Appeal Decision

Appeal Ref: 6005832

Woodfold Park Stud, Woodfold Park, Mellor, Lancashire BB2 7QA

- The appeal is made under section 78 of the Town and Country Planning Act 1990 (as amended) against a refusal to grant approval required under Article 3(1) and Schedule 2, Part 1, Class A of the Town and Country Planning (General Permitted Development) (England) Order 2015 (as amended).
 - The appeal is made by Mr Chris Ellison against the decision of Ribble Valley Borough Council.
 - The application Ref is 3/2025/0899.
 - The development proposed is rear single-storey extension to detached dwellinghouse.
-

<p>AREEBA ARCHITECTURE</p> <p>DAISYFIELD MILL, BLACKBURN, BB1 3BL 01254 560701 / 07988175604</p>	Client: Mr S Daial	Drawing No: BB355-100-K
	Project: Woodfold Park Stud Woodfold Park, Mellor, Blackburn, BB2 7QA	Purpose of Issue: Planning
	Scale: 1:100 @ A1	Date: Nov 2025

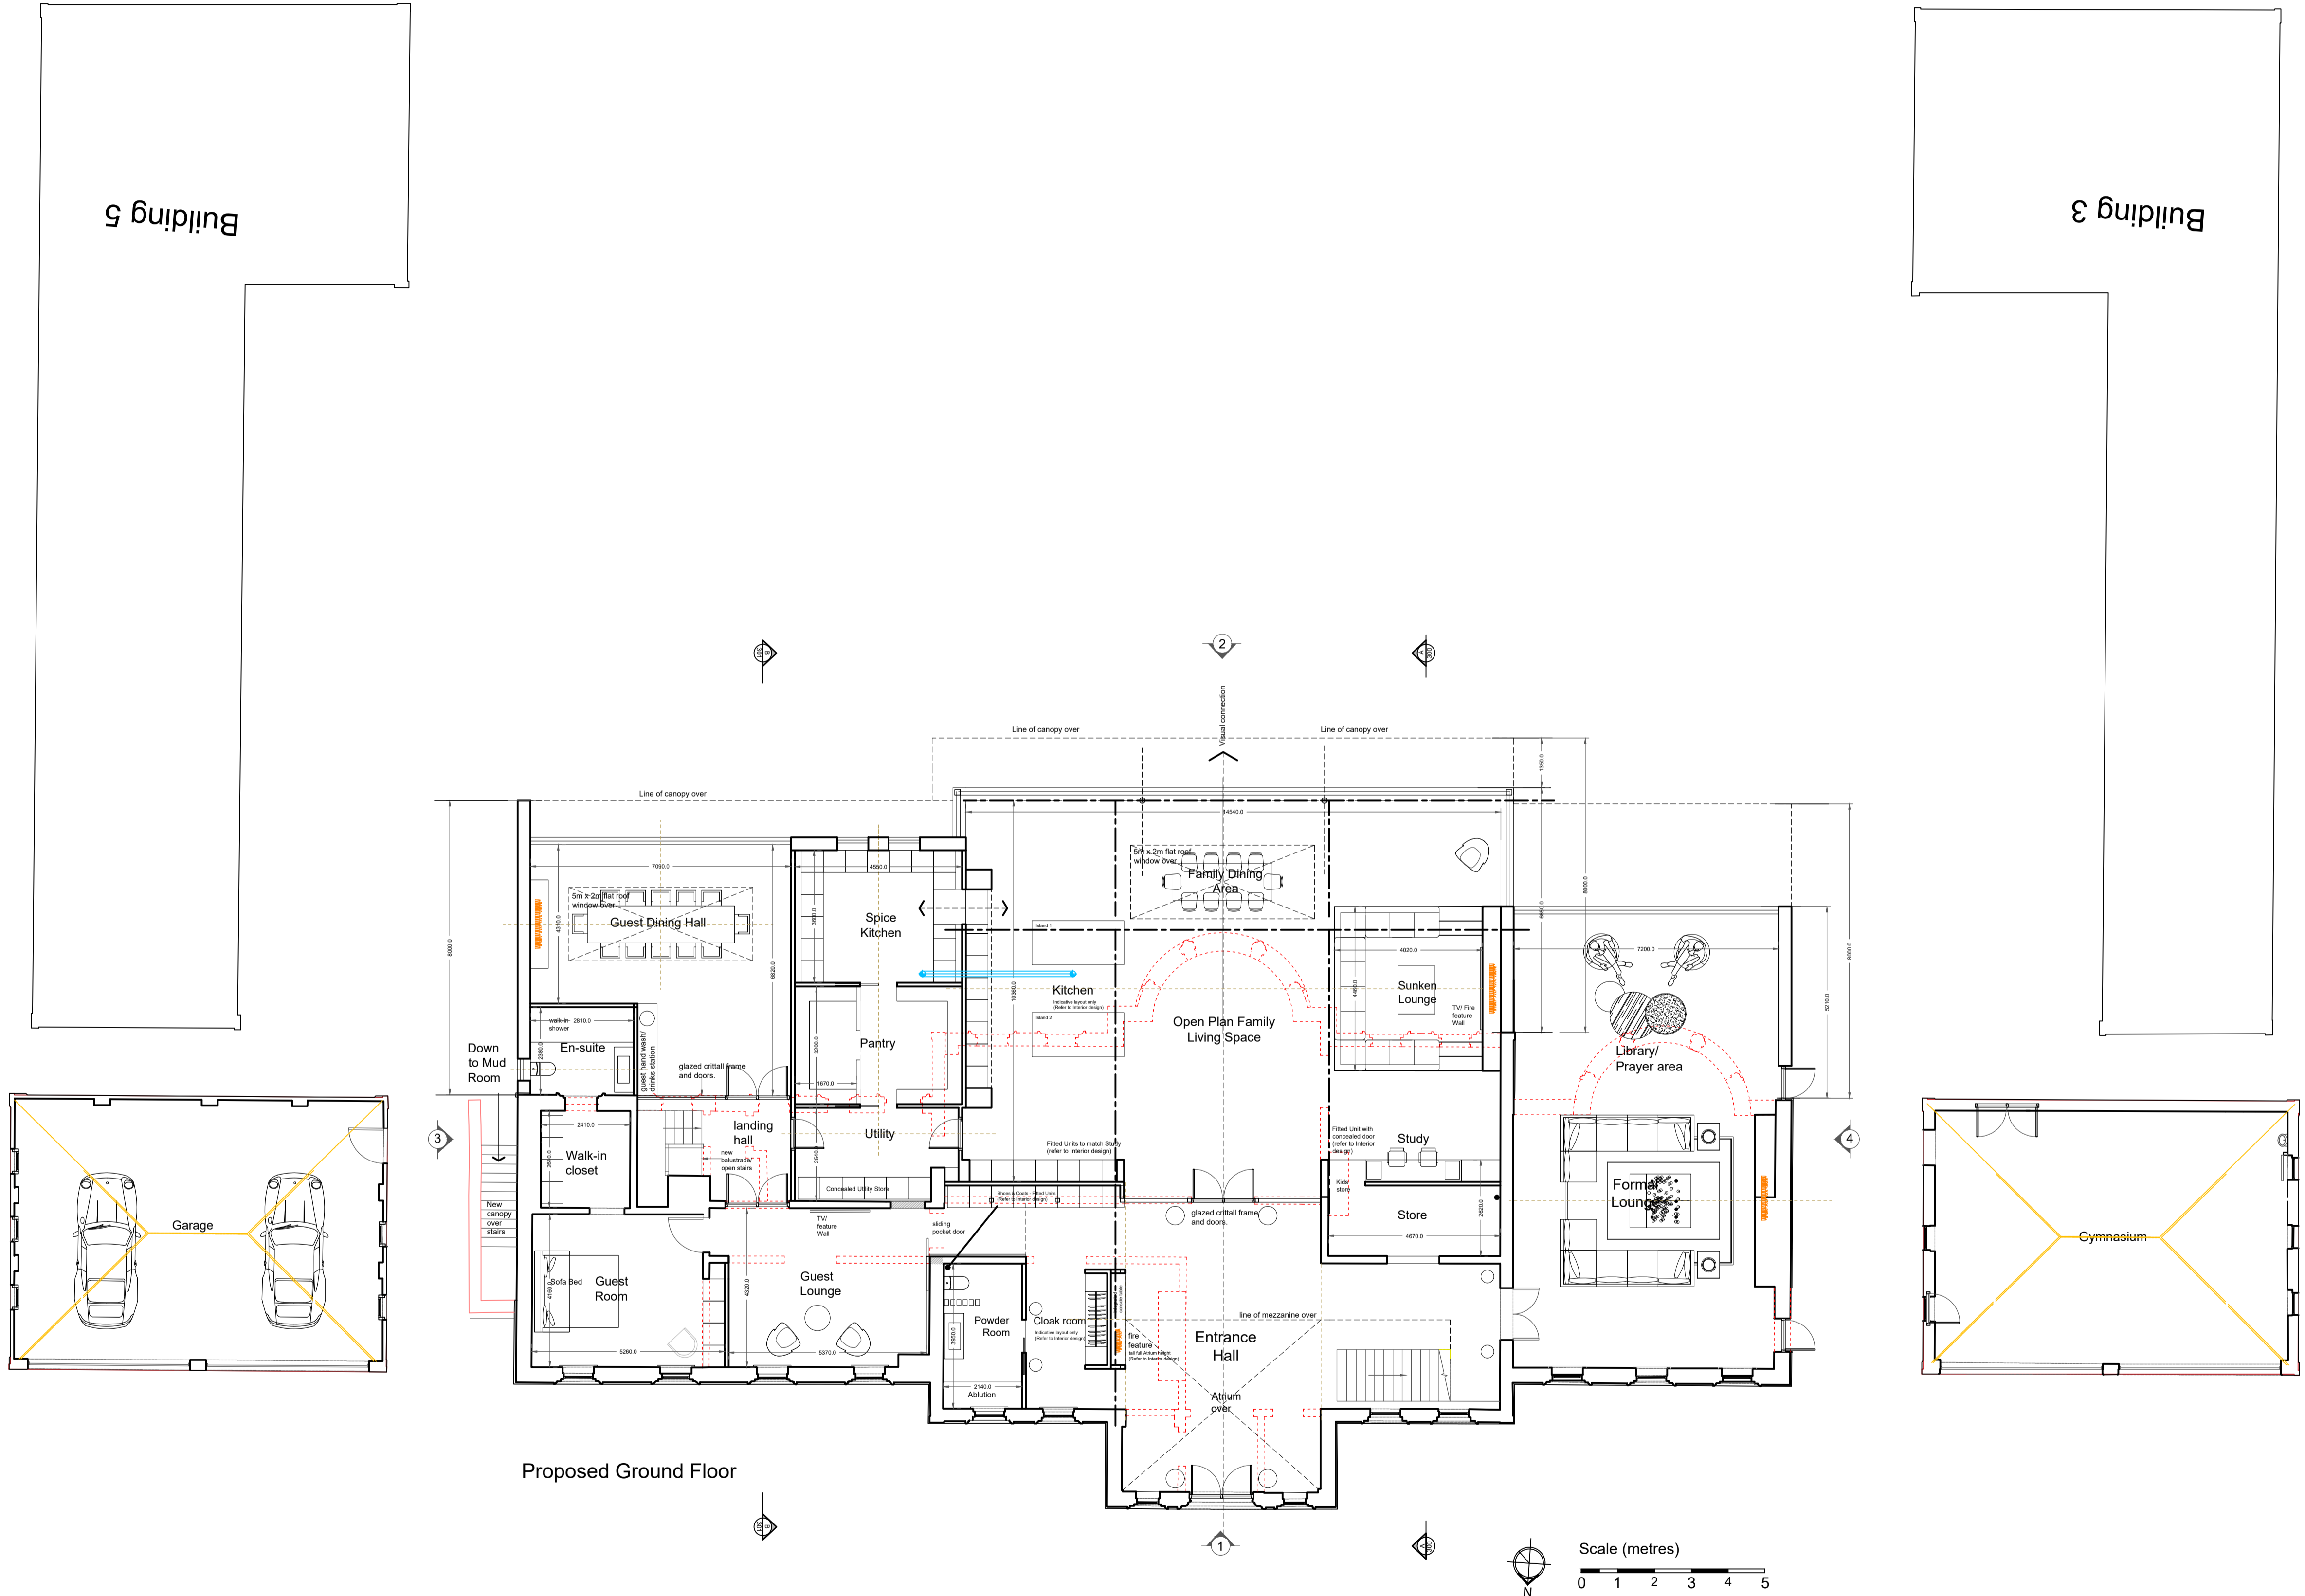
6. The appeal property is a large, detached 2-storey dwelling with a stepped rear elevation. The proposal relates to the erection of a single storey extension to the rear of the building. The submitted plans and application form show that the extension would project up to 8 metres beyond the rear wall of the original dwellinghouse, broadly following the staggered arrangement of the existing rear elevation.

10. Applying paragraph A.1(j)(iii) of the GPDO, and having regard to the interpretation set out in the Technical Guidance, the proposed extension would project beyond a number of side walls created by the stepped rear elevation, and its width would exceed half the width of the original dwellinghouse. The proposal would therefore fail to comply with this limitation and would not constitute permitted development.

11. Paragraph A.1(g)(i) states that, to be permitted development, a single storey extension must not extend more than 8 metres beyond the rear wall of the original dwellinghouse. The Technical Guidance confirms that this measurement should be taken from the base of the rear wall of the original house. Measured in this way, the proposed extension would not exceed the 8-metre limitation and would therefore comply with paragraph A.1(g)(i).
